Subject: Walgrave Parish Council Comments

Walgrave Parish Council response to the Greenhill Solar Farm DCO

Title:
Figure 8.1.1 Site Locations and Study Area
Green Hill A & A.2

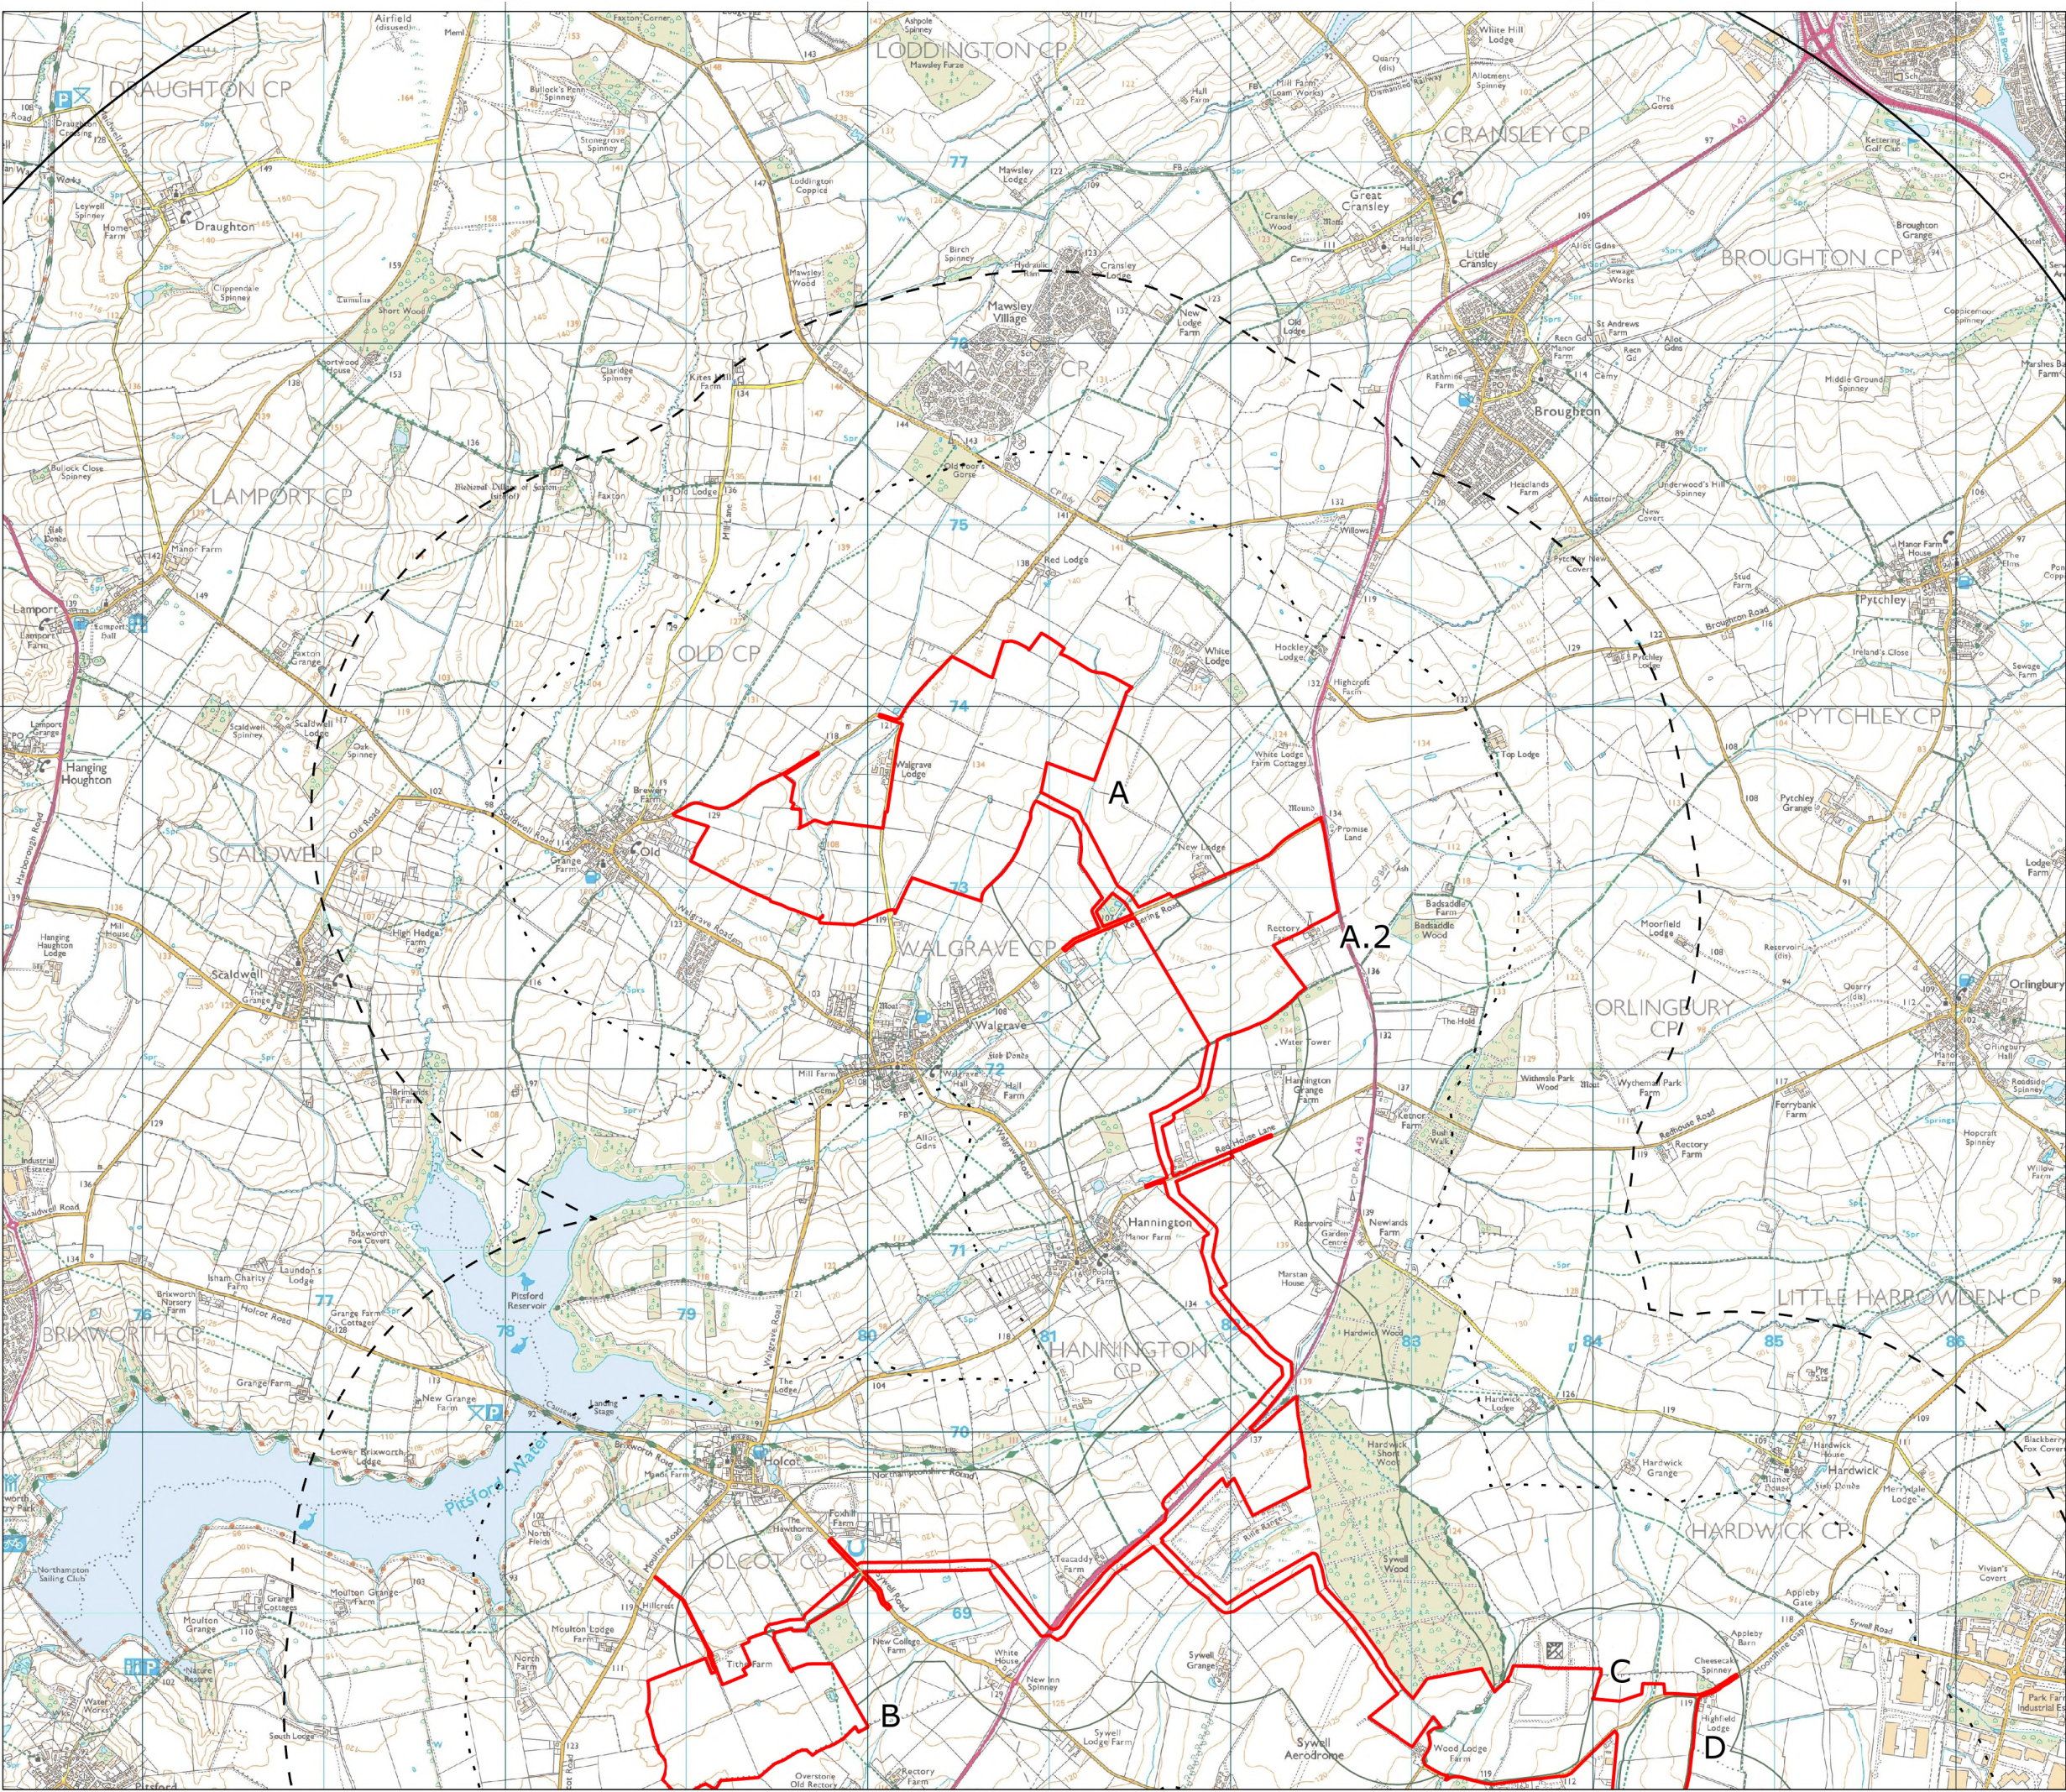
The proposed development spans a substantial area, transforming a large expanse of rural agricultural land into an industrial-scale solar power installation. This development is too large for the landscape and context in which it is proposed. The surrounding area is rural countryside and rural residential, the development would dominate the landscape which cannot absorb a large-scale solar development.

The vast physical footprint of this proposal would significantly alter open views due to the huge scale of the proposed development and the proximity of solar panels to the road.

Site A2 would cause a major visual impact along Kettering Road, one of the main approaches into Walgrave. This currently open, rural vista will be replaced by a prominent, industrial-scale installation, which will dominate the landscape and detract from the village's countryside setting.

Site A will similarly cause a significant visual intrusion along Newlands Road, altering key views in and out of the village and permanently impacting the rural character of the area.

The proposed development does not comply with key National and local policies aimed at preserving the rural character and visual appeal of the open countryside. The size and scale of the proposed power installation, particularly the visual impact of Sites A and A2 would lead to irreversible harm to the landscape.
